Ann Machado - RE: Statement from Stroudwater Village Association regarding Verizon Wireless Conditional Use Application, 1877 Congress Street, Portland

My wife Lindley and I are homeowners in the Stroudwater Farms development. We have recently become aware of the October 21, 2015 Conditional Use Application submitted by Verizon Wireless to the Zoning Board of Appeals. I understand this application was on the agenda of a recent meeting of the Board and is pending a decision at an upcoming meeting. The proposed facility is on a lot at 1877 Congress Street.

PROPOSED SITE PLAN

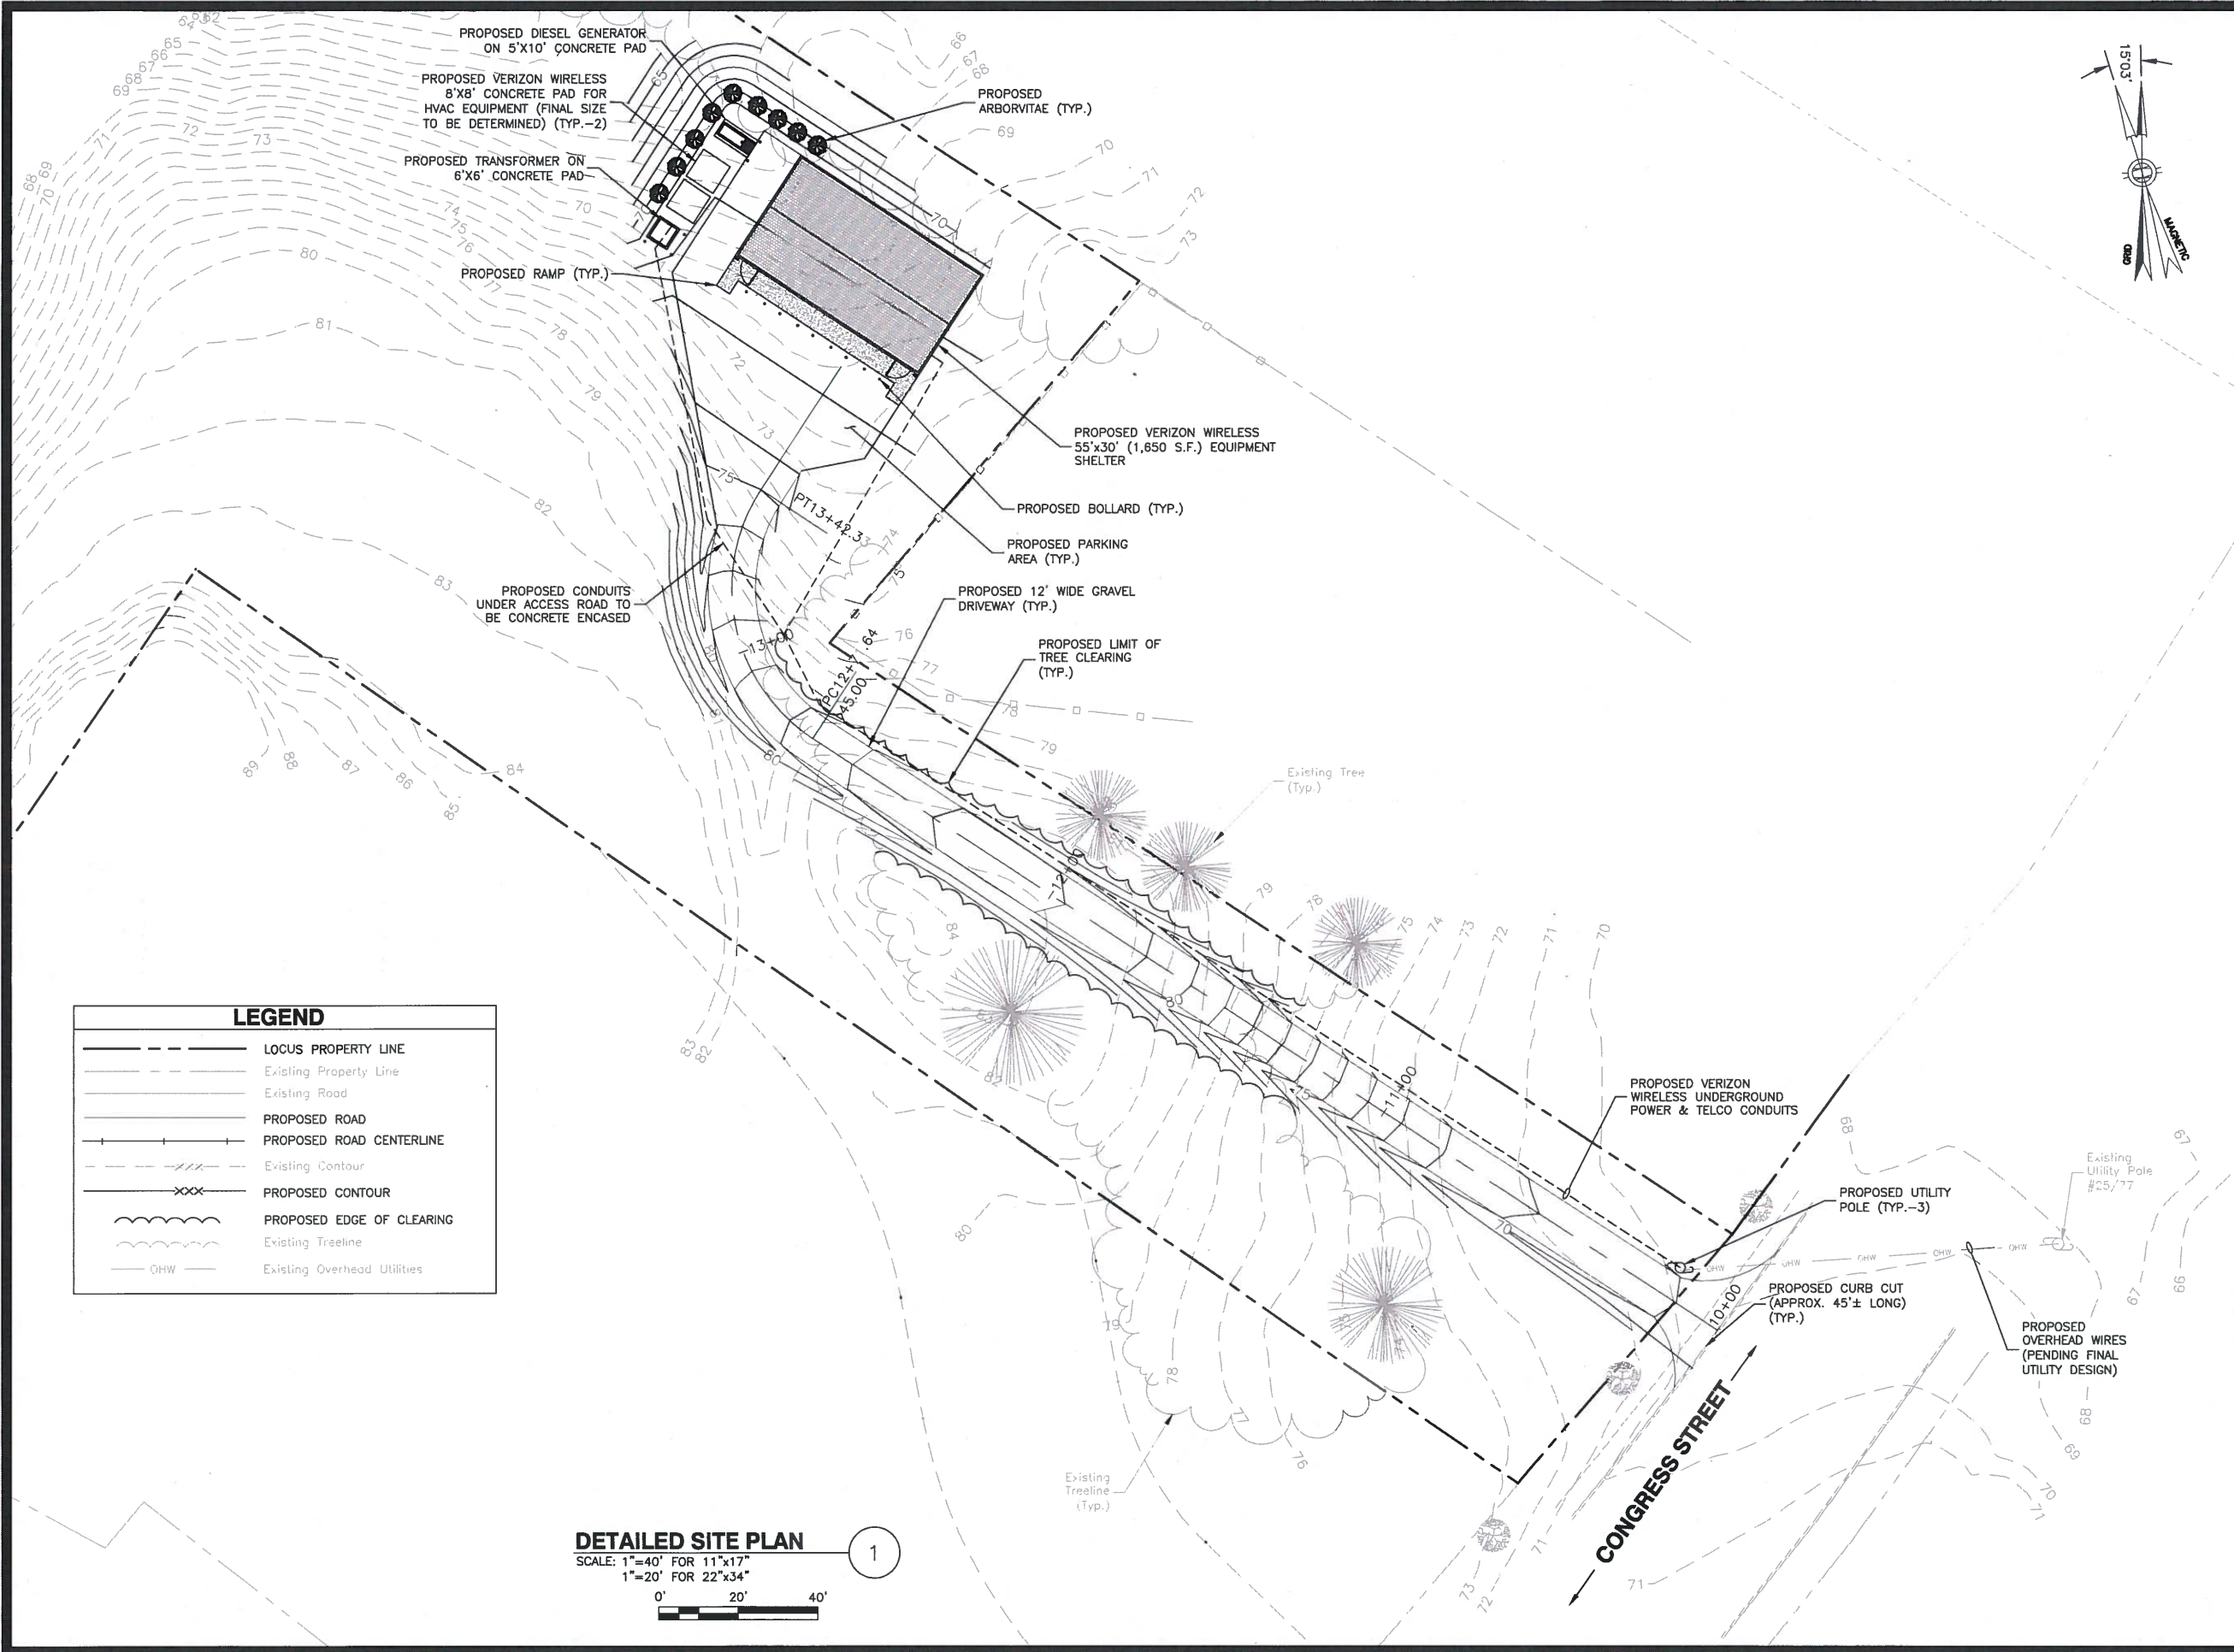
2) The application indicates arborvitae will be planted, yet did not submit a landscaping plan.

4) Verizon wants to acquire 4 acres yet seeks to shoehorn the Facility in one small corner of the property closest to its Stroudwater Farm neighbors and another Congress Street abutter.

Is there a reason for its location? Is this the optimal location given the lower grade of the site so as to be less conspicuous? The center of the 4-acre lot appears to be at least 15' higher so the proposed site may be the best spot, but I do not have sufficient data to form an opinion.

SHELTER ELEVATION (NORTH)

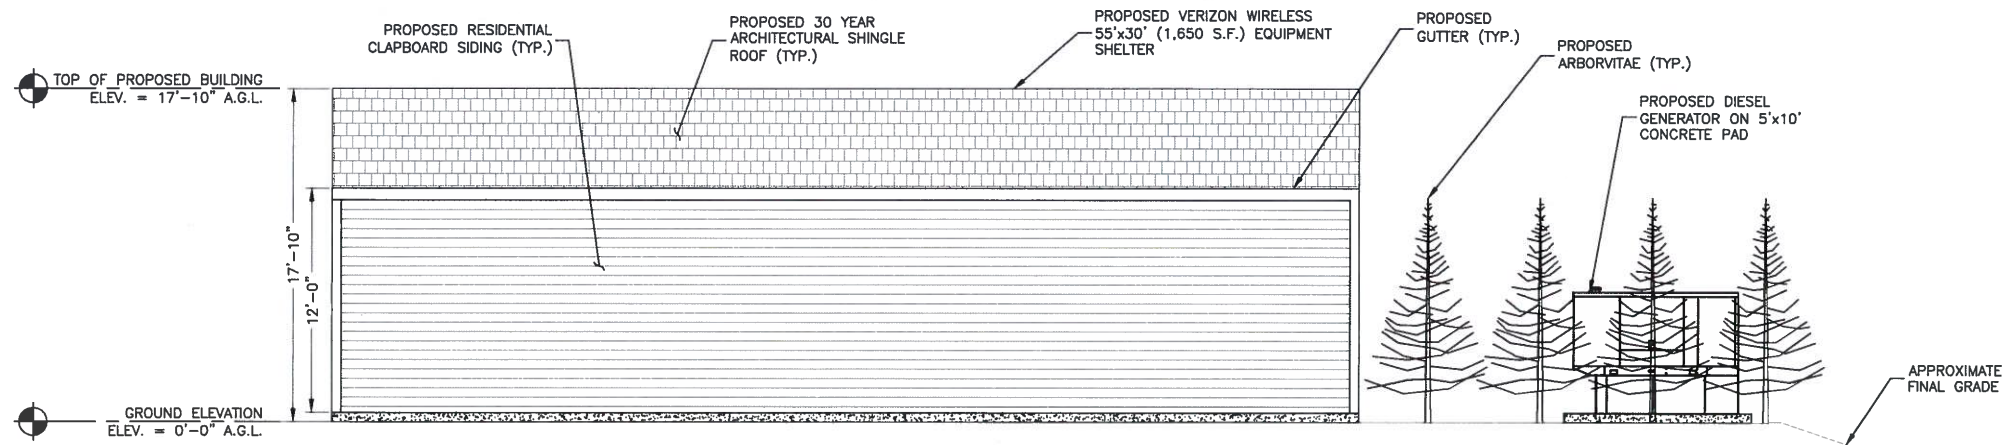
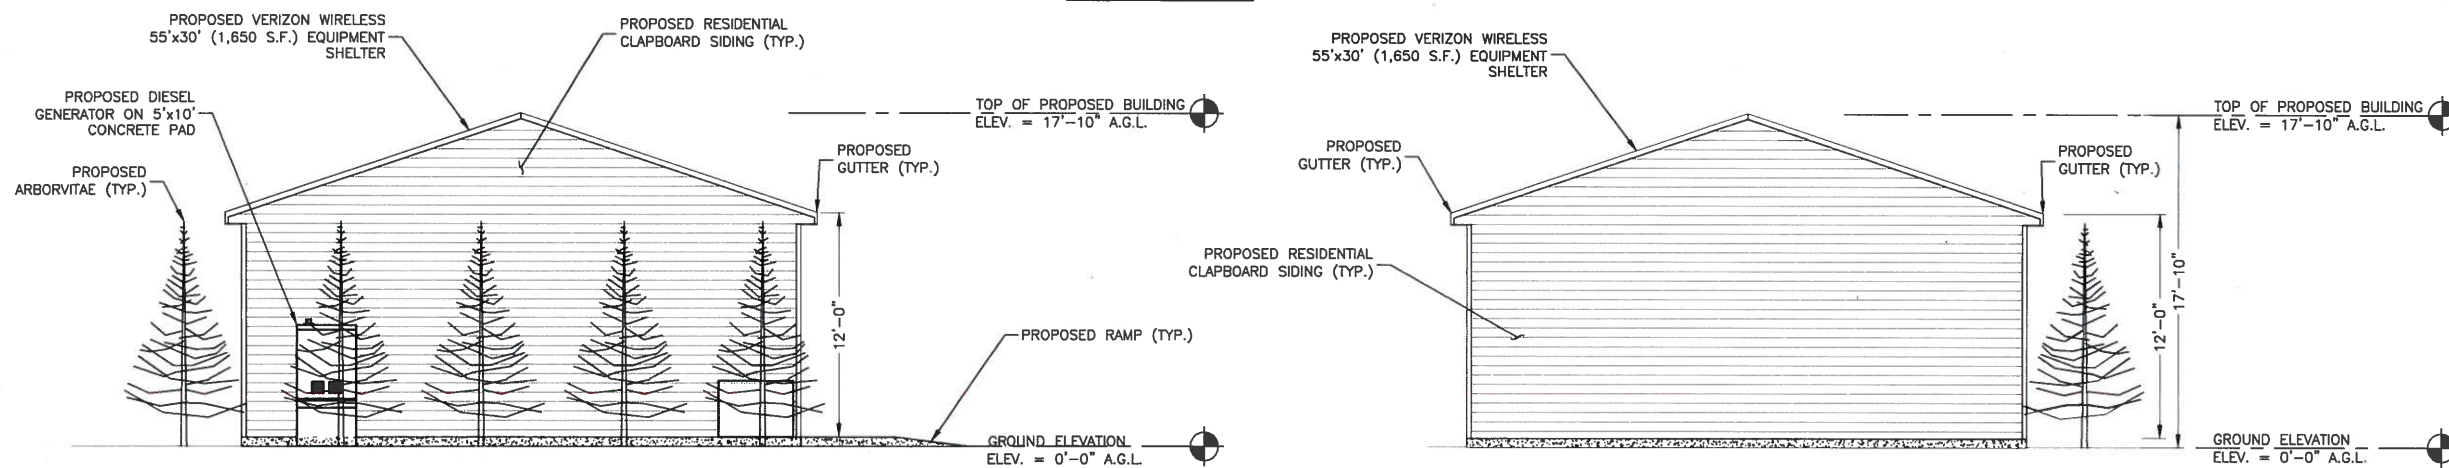
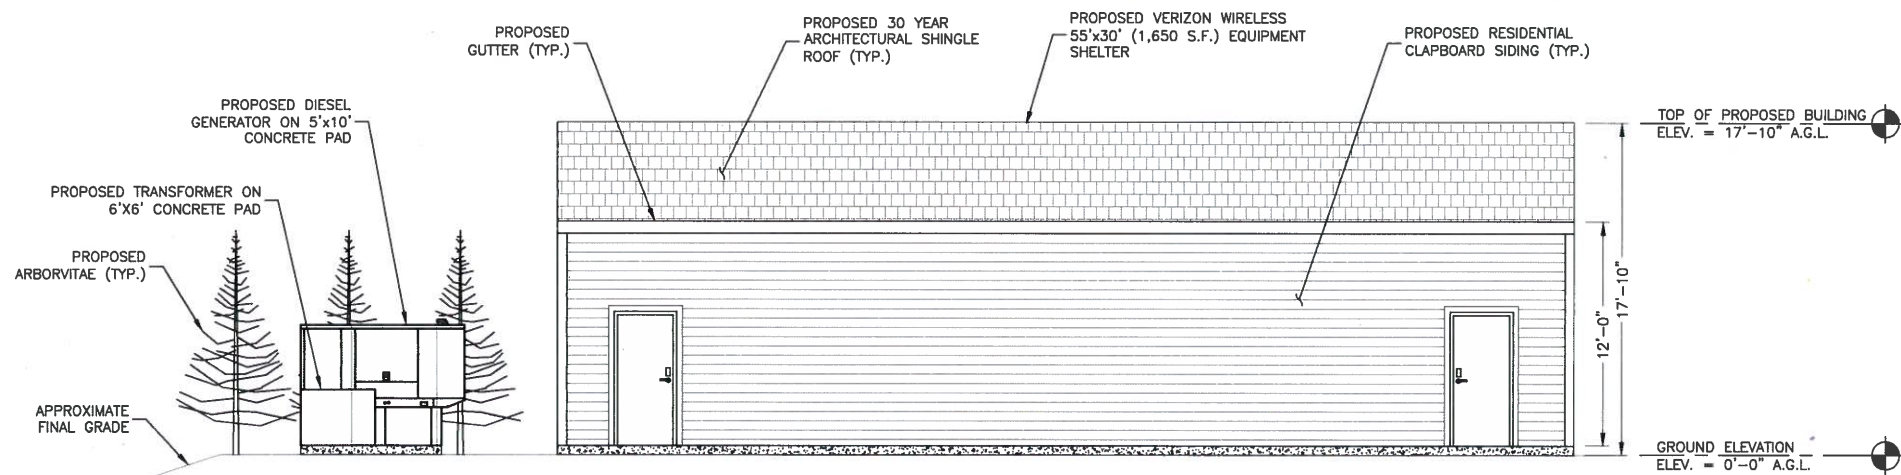
The Facility plans show a final elevation just below 18' above grade.

Lots 6 and 7 are most adversely affected given their close proximity. Is it necessary for the building to be so tall? Could the building be partially constructed below grade to lessen its height and thereby better "fit in to the surrounding neighborhood" as quoted from the application?

Given its plan, how can the Facility truly "fit in to the existing landscape of the site"?

The elevations should clearly state the clapboard siding would be vinyl.

Why are gutters needed? Properly insulated buildings don't need gutters. Storm water can easily be collected below grade with perimeter drainage and directed a designated area. Further, gutters require constant maintenance.

7) Have you considered designing the Facility to appear like an old barn?

The present design of the Facility is not inspiring. The planned vinyl sided warehouse offers NO architectural appeal in one of Portland's oldest neighborhoods. Instead of the monolithic plastic building with no break (windows) in its design, perhaps a clapboard (or shingle) building shaped and

Z-4

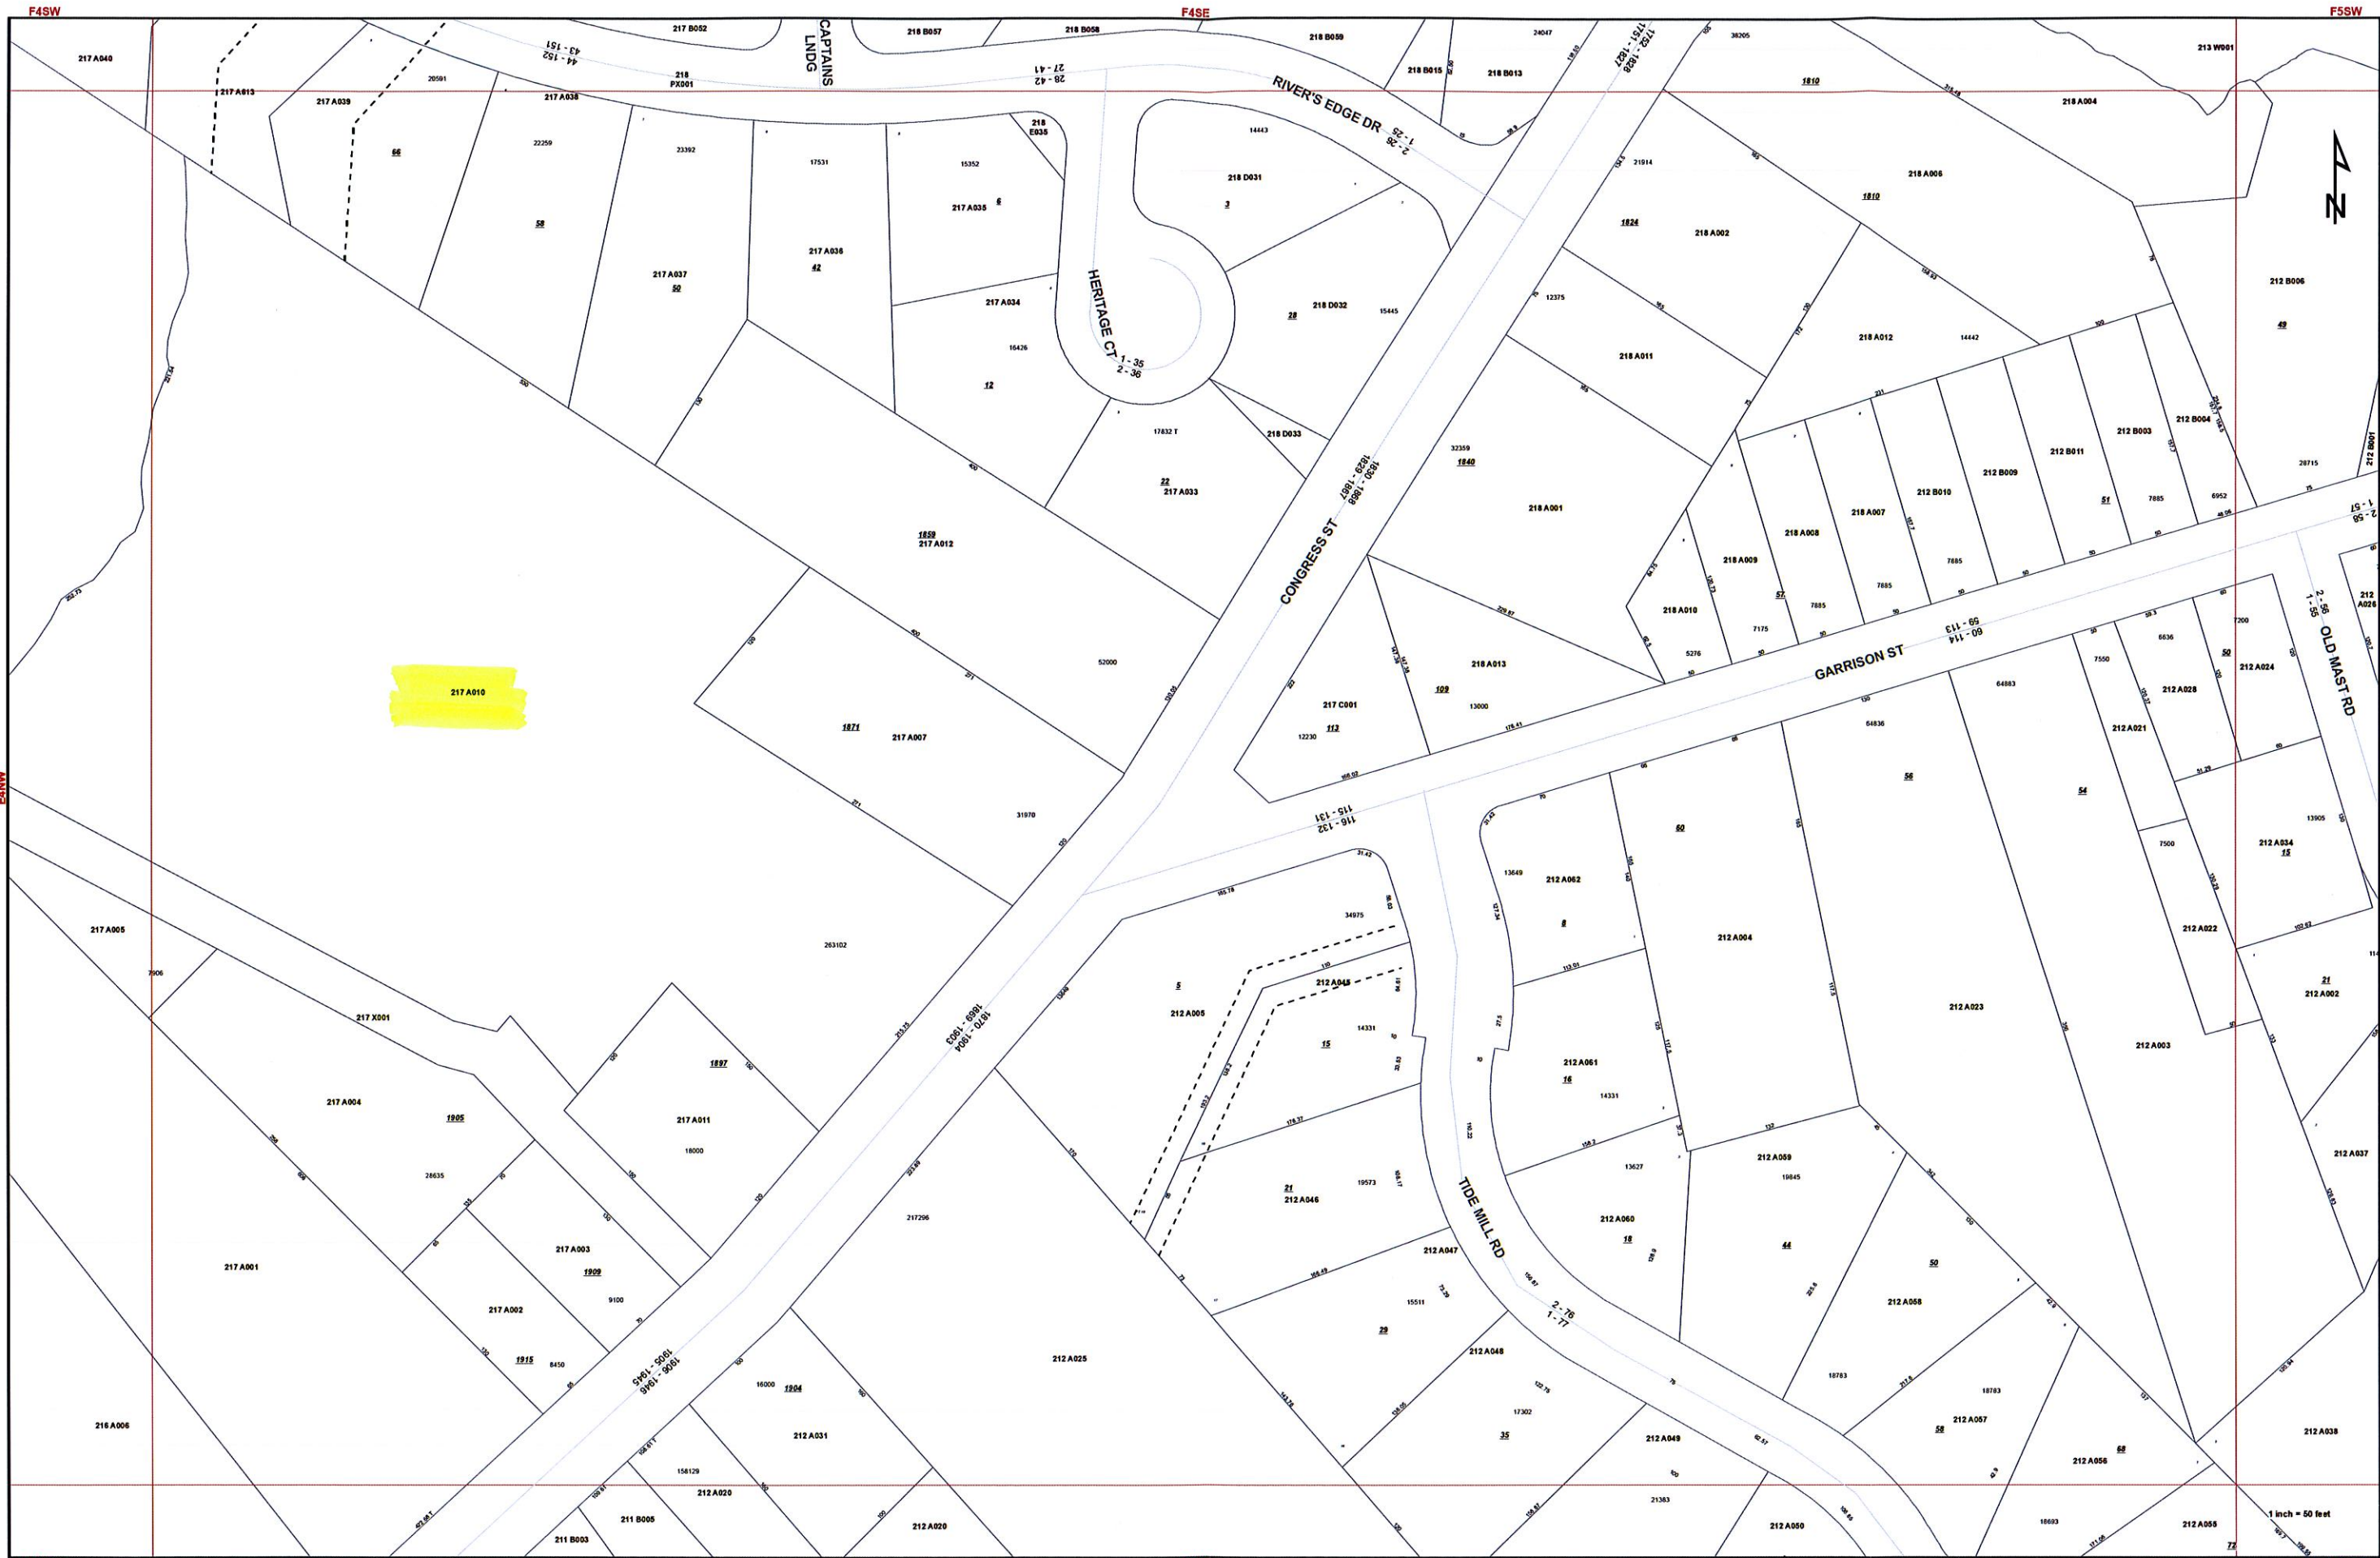
3) Why is the diesel generator planned for the west side of the Facility?

I would think Verizon would want to be a good neighbor and keep the generator away from its immediate neighbors. This plan fails that.
